TRAFFIC IMPACT STUDY

**Cathedral Rock Commons
El Paso County, Colorado**

September 2021

Please add PCD File
No. P-21-001

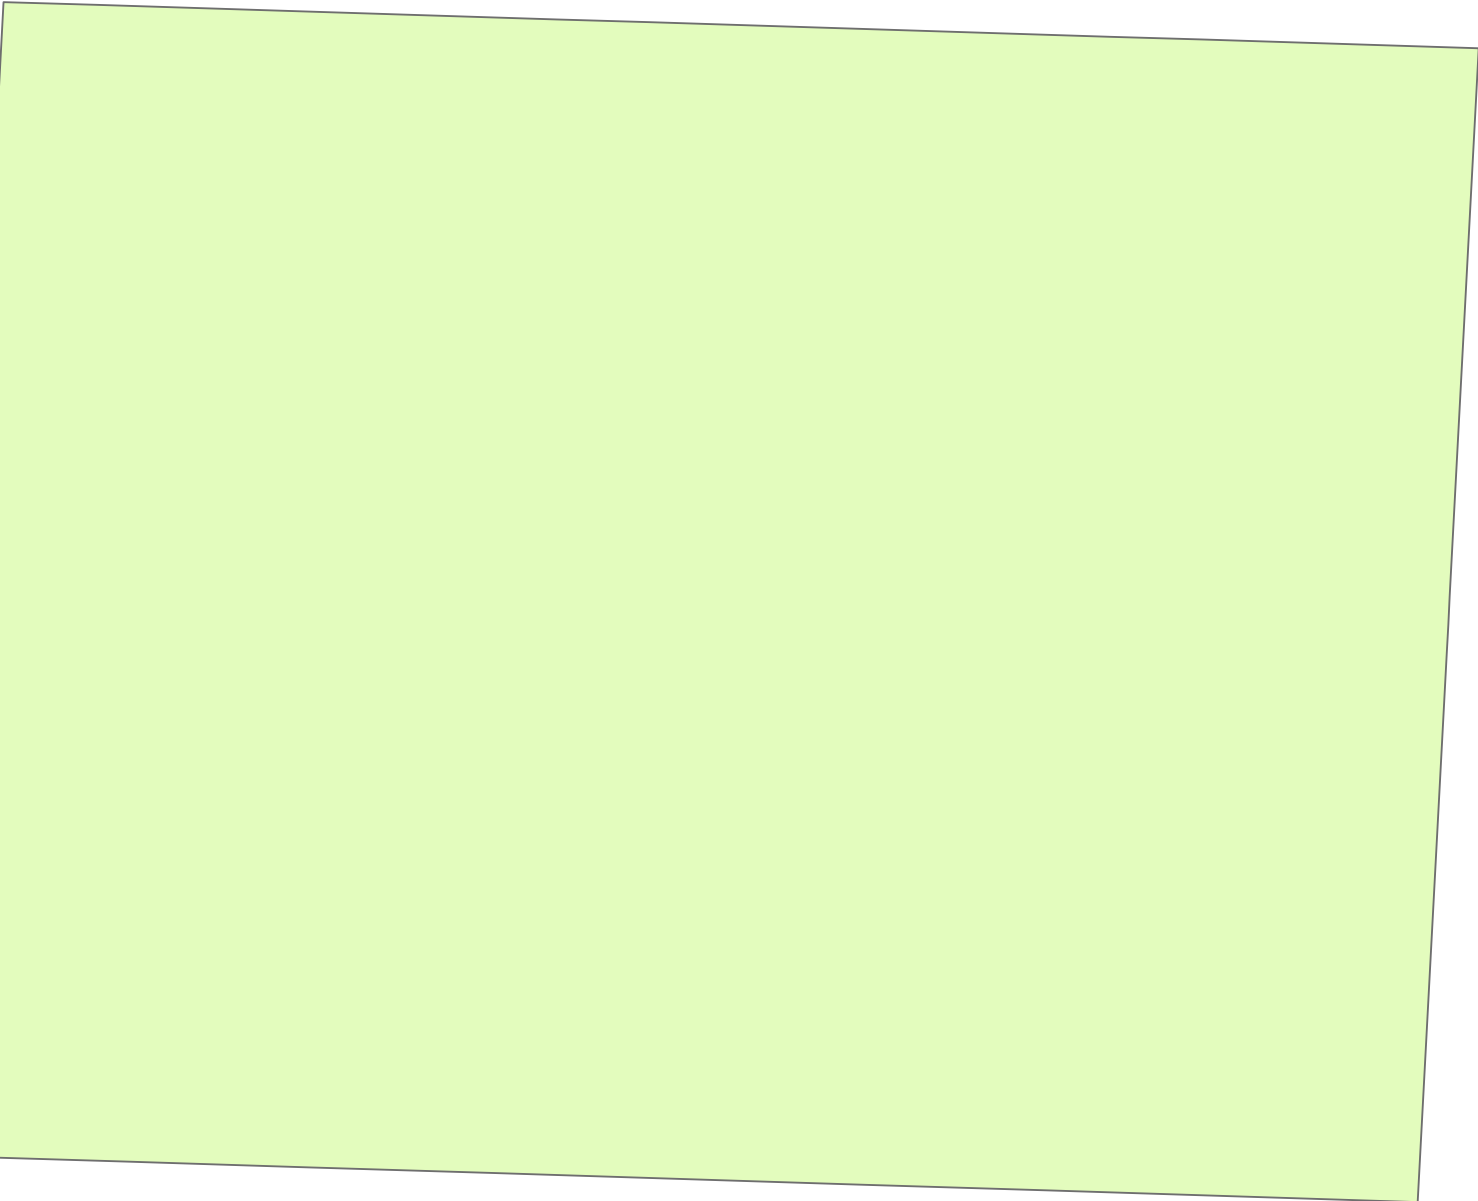
Please revise study area to include adjacent subdivisions to the east, as residents use Spanish Bit Drive as access to Struthers. Also include North Gate Blvd in study area, or provide a more extensive analysis of why it should not be included in the study area.

Spanish Bit Drive  
MONUMENT, COLORADO 80917  
6.57 ACRES  
REZONE MAP

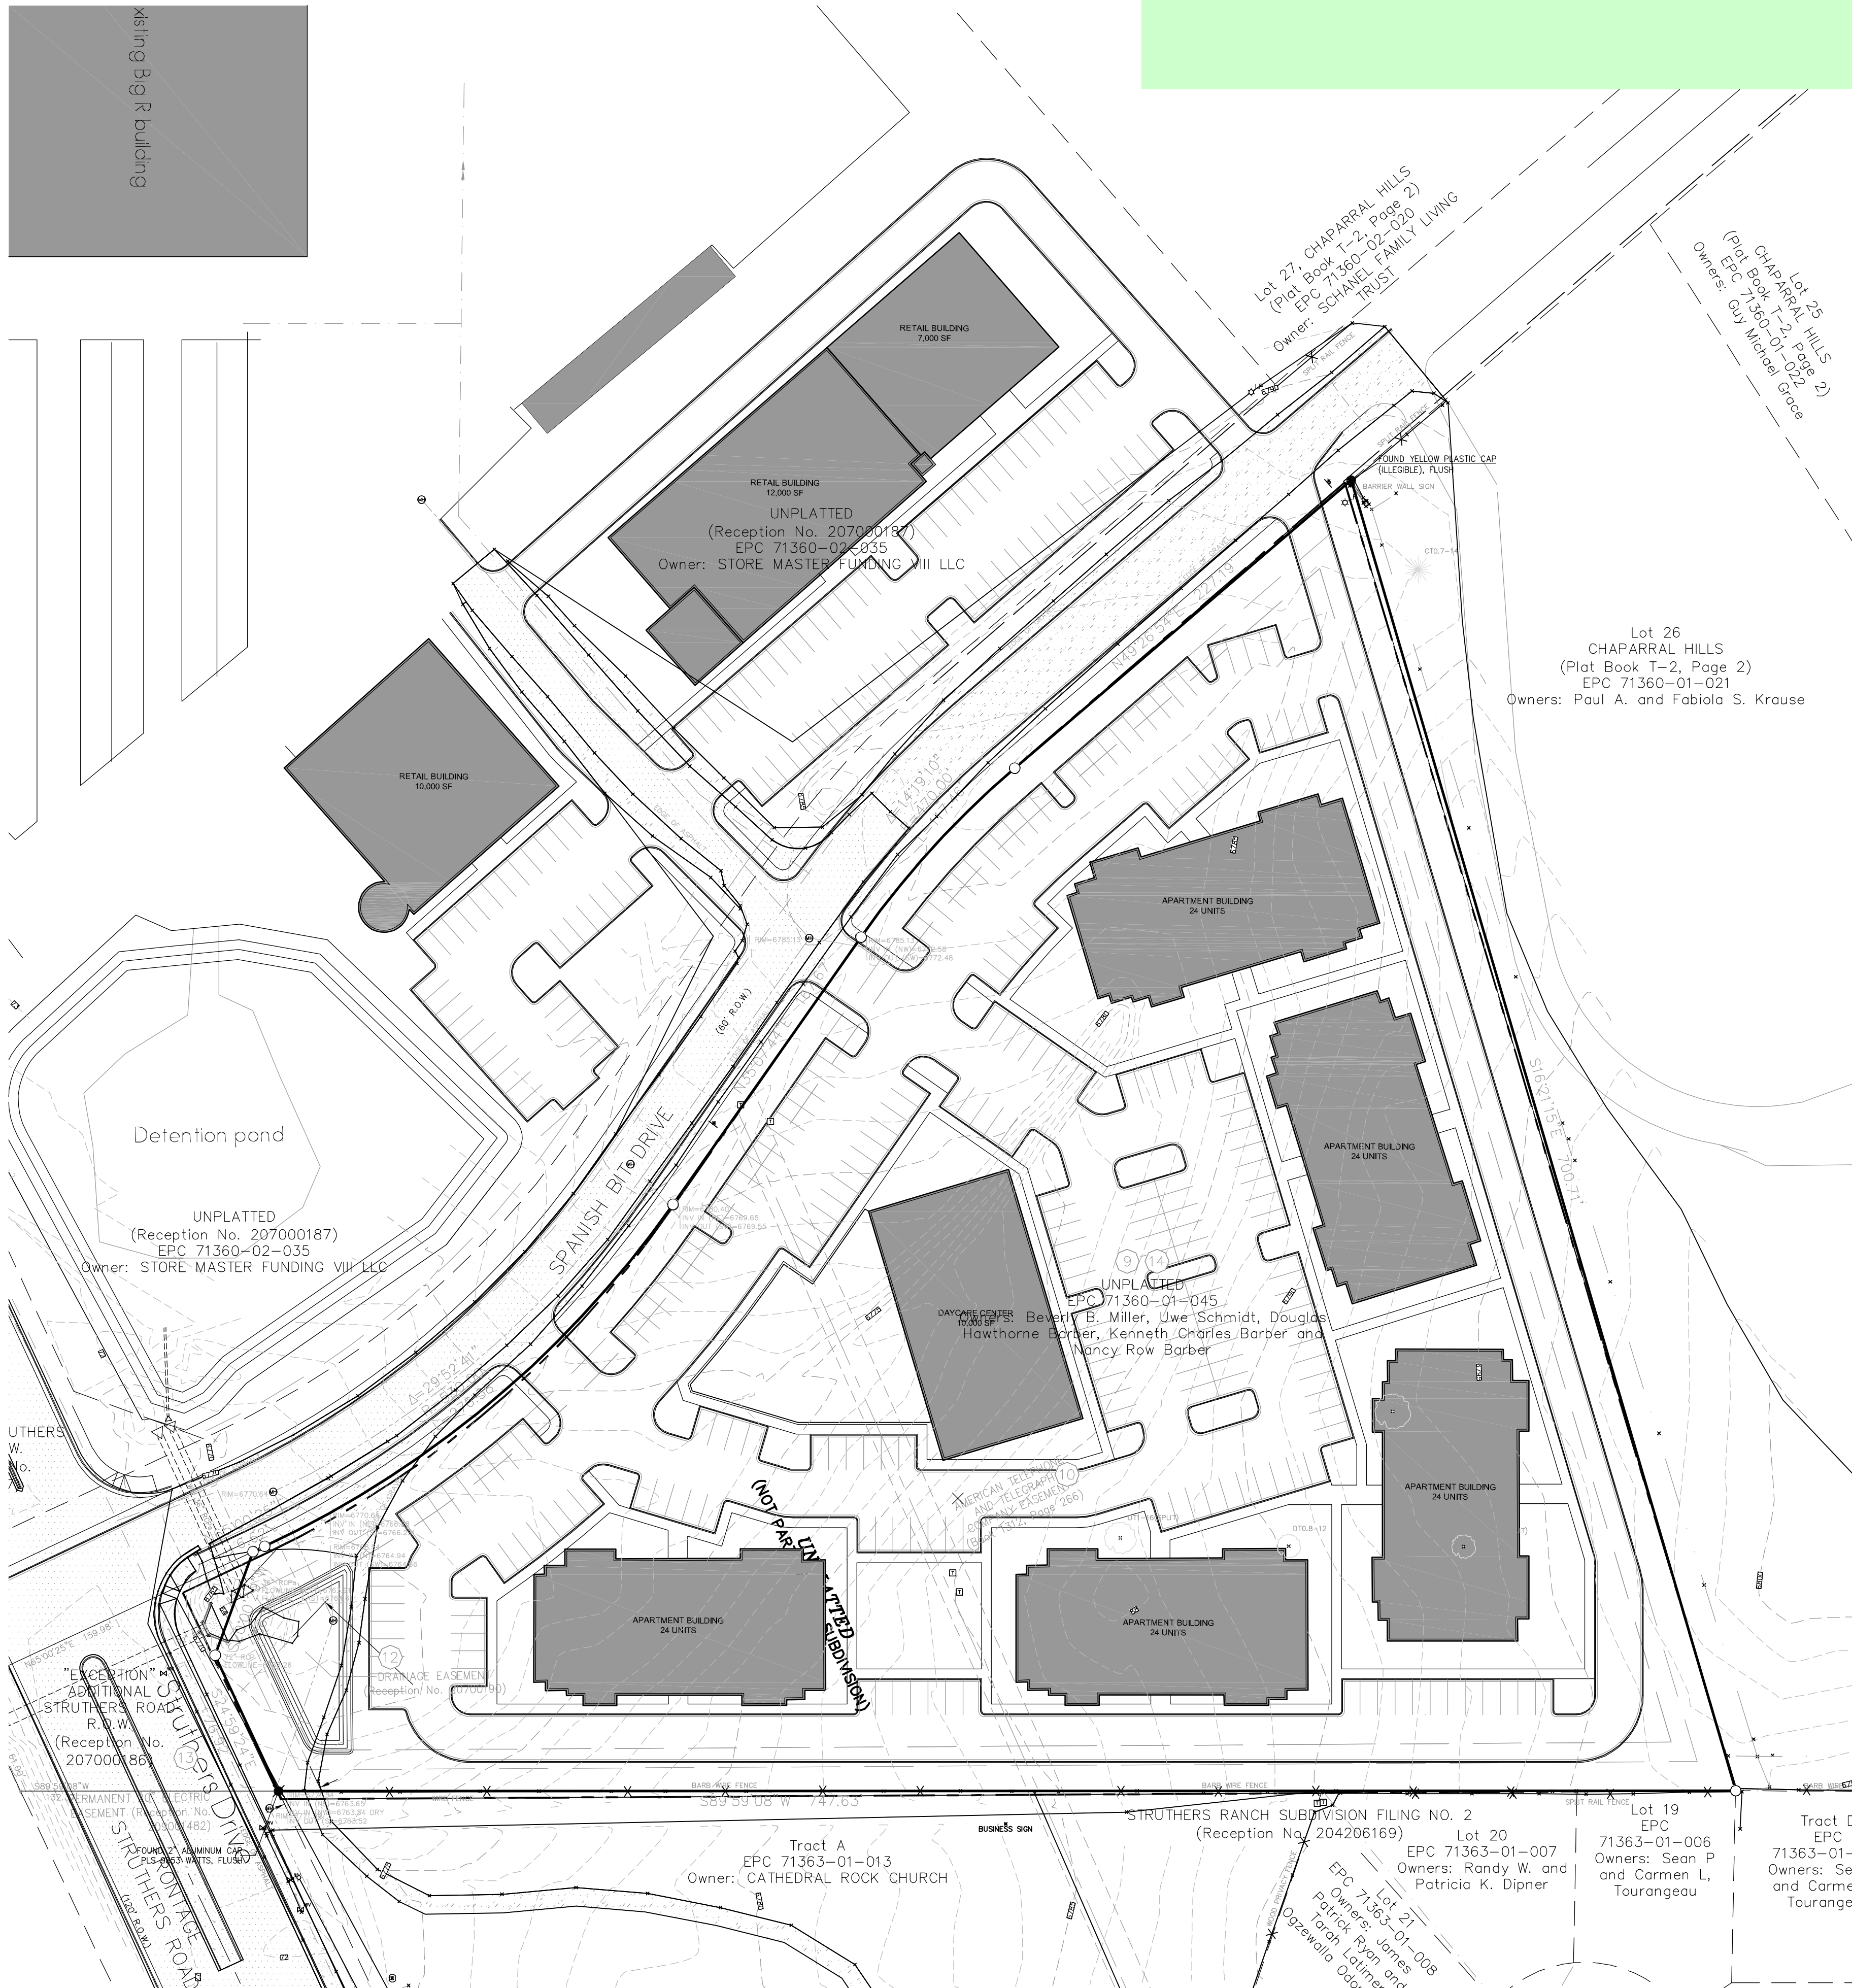
Please include access C in analysis. Access points in parcel should be studied in TIS.
